Recommendation Report for Planning Permission for Works or Extension to a Dwelling

REF NO: BE/59/21/PL

LOCATION: 339 Chichester Road
Bersted
PO21 5AN

PROPOSAL: Replacement of blockwork boundary wall with fence and new vehicular access (resubmission of BE/149/21/PL).

SITE PLAN - SHOWING VISIBILITY SPLAYS
1:500 SCALE (at A3)

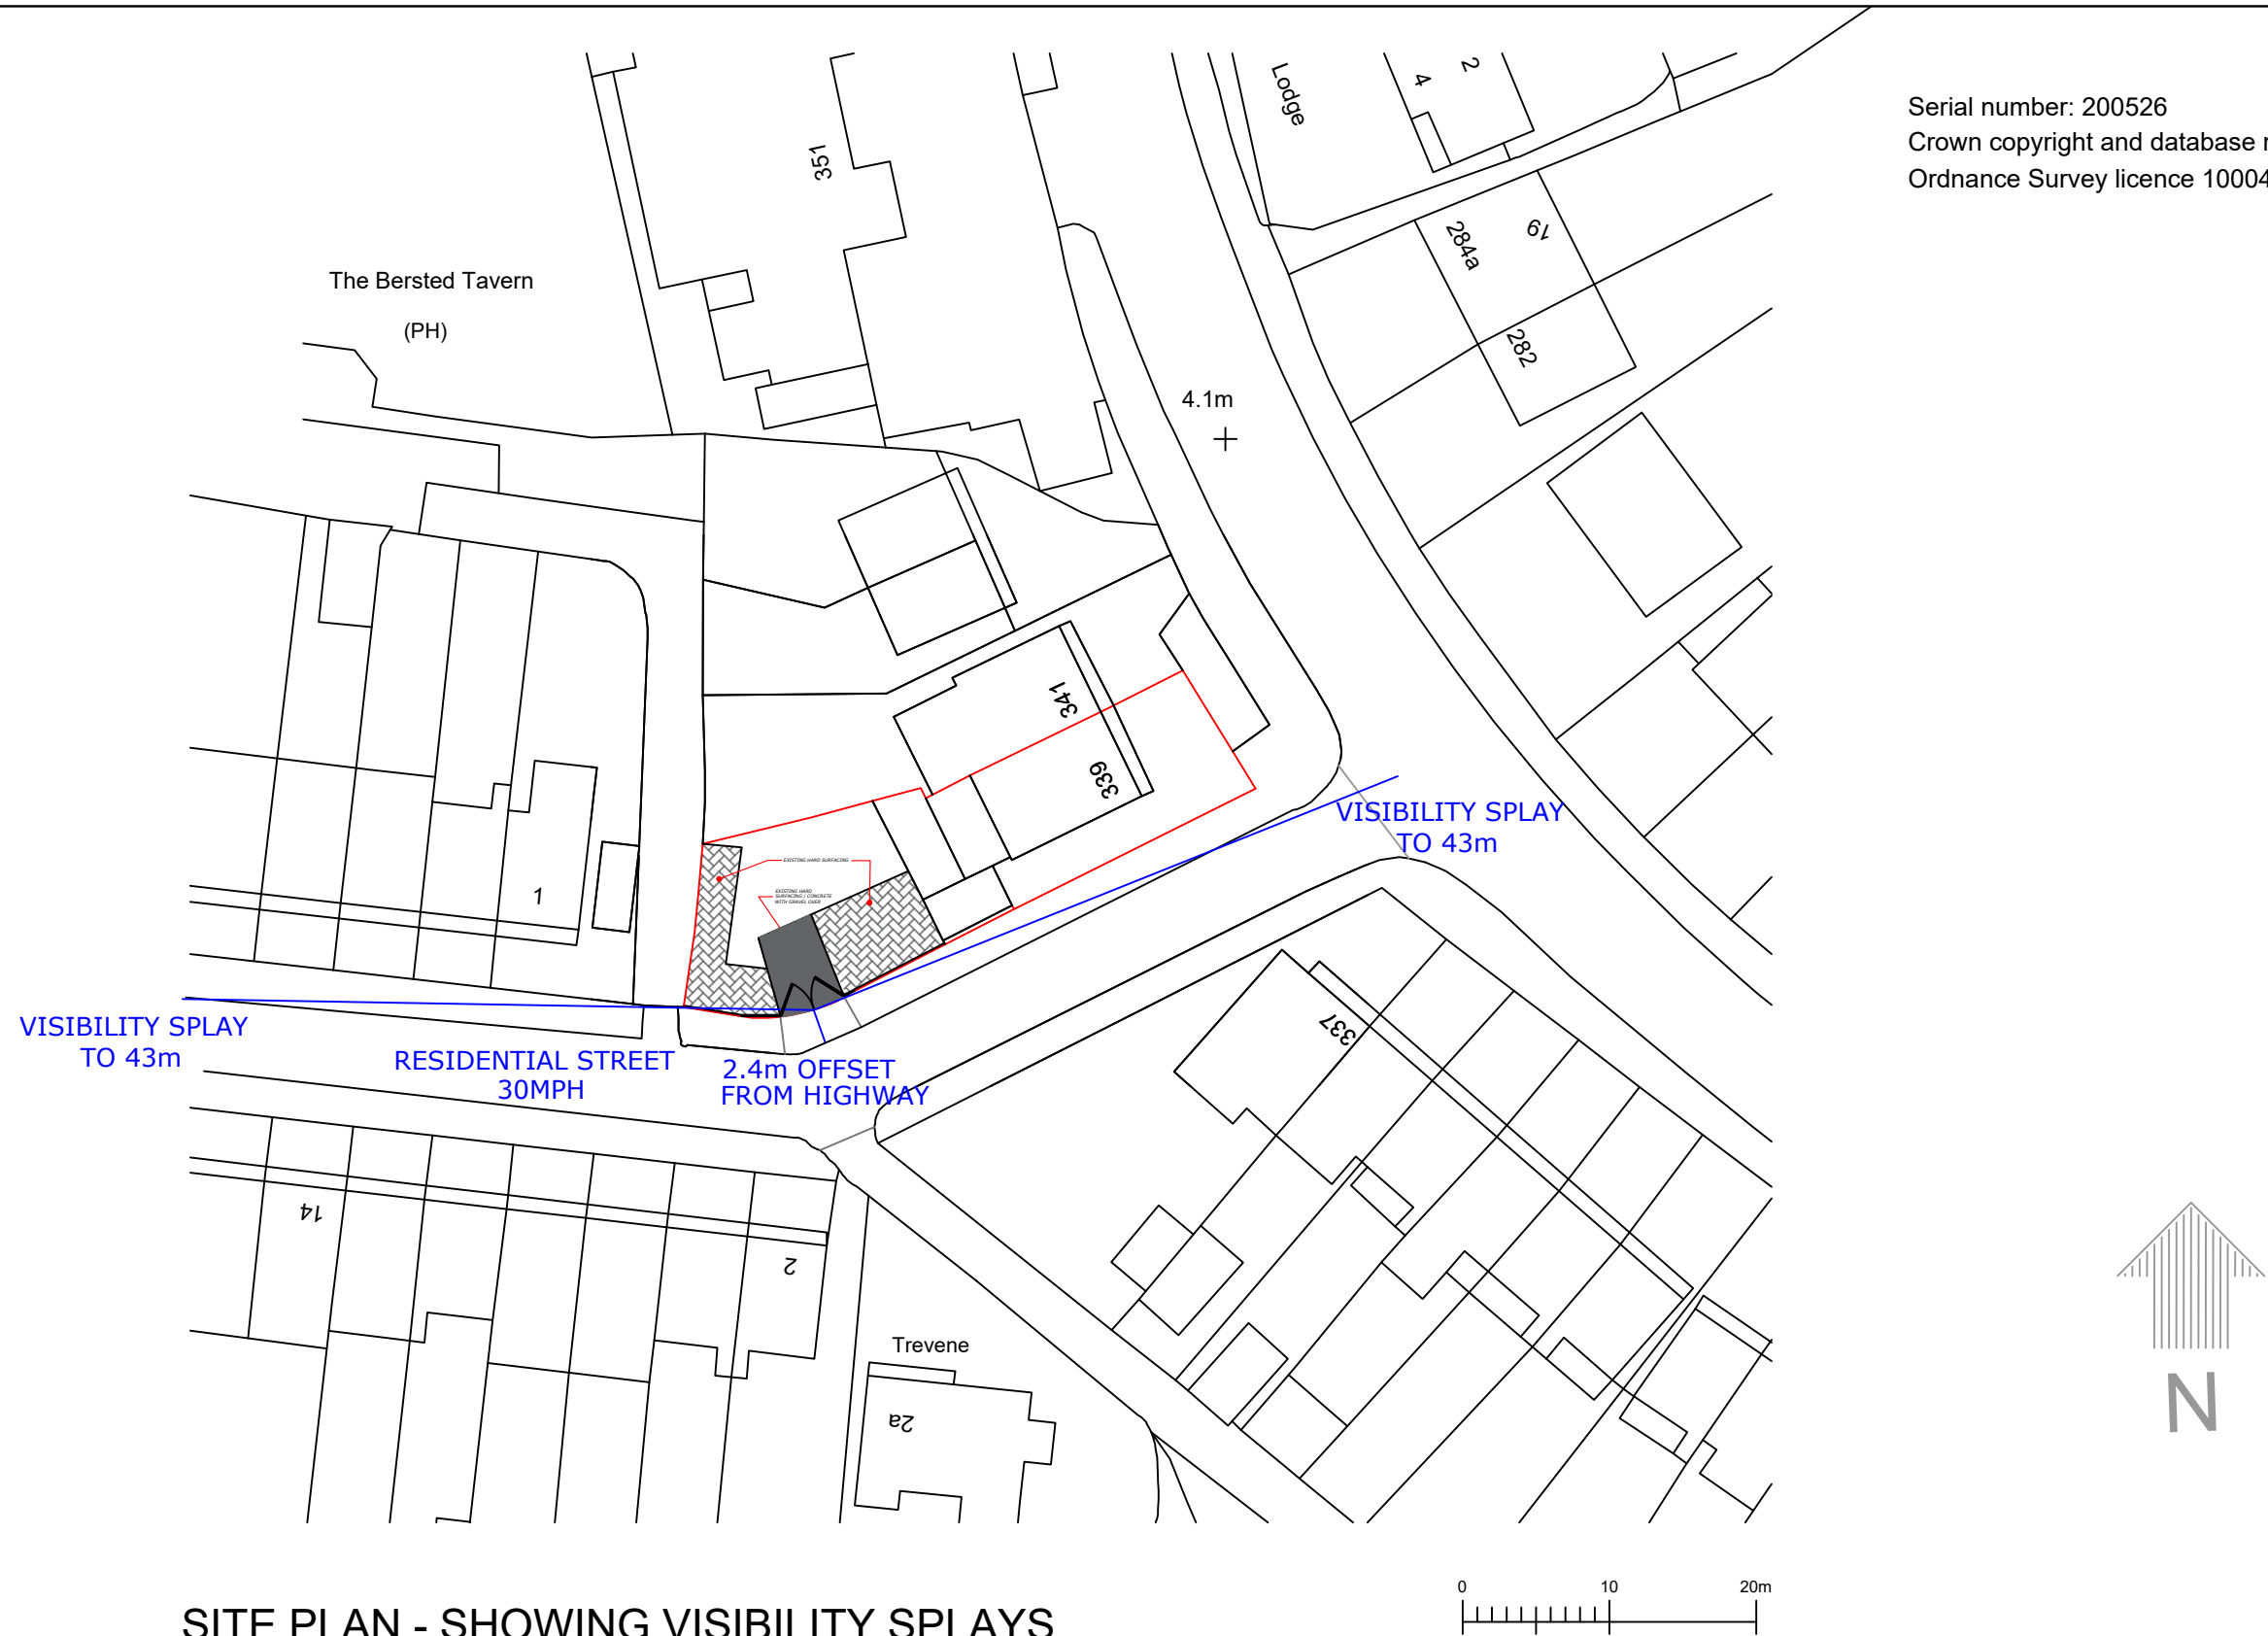
Objection on the grounds of highway safety - the new vehicular access is on a bend and the plan showing the visibility splay does not take into account that residents cars are parked near the bend which makes it impossible for the visibility splay of 43m to be achieved. It is a safety issue for pedestrians, children and cars if this access is allowed. Bedford Avenue, where the vehicular access is, is subject to a traffic mitigation scheme.

As Bedford Avenue is subject to a speed restriction of 30 mph. Minimum stopping sight distance of 43m in each direction, set back 2.4m from the back edge of the carriageway is required. The applicant submitted a site plan demonstrating visibility splays to this requirement. These splays shall thereafter be kept clear of all obstructions to visibility above a height of 0.6m above the adjoining road level, and this can be secured by condition.

The LHA acknowledges written representations, highlighting that on-street parking occurs close to the proposed access. Parking in visibility splays in built up areas is quite common, yet it does not appear to create significant problems in practice. The absence of wide visibility splays at minor accesses will encourage drivers to emerge more cautiously, similarly to how vehicles emerge onto the highway when visibility along the carriageway is restricted.

- 3 No use of the access shall take place until such time that visibility splays of 2.4 by 43m have been provided at the proposed site vehicular access onto Bedford Avenue in accordance with the approved planning drawings. Once provided the splays shall thereafter be maintained and kept free of all obstructions over a height of 0.6m above adjoining carriageway level or as otherwise agreed.
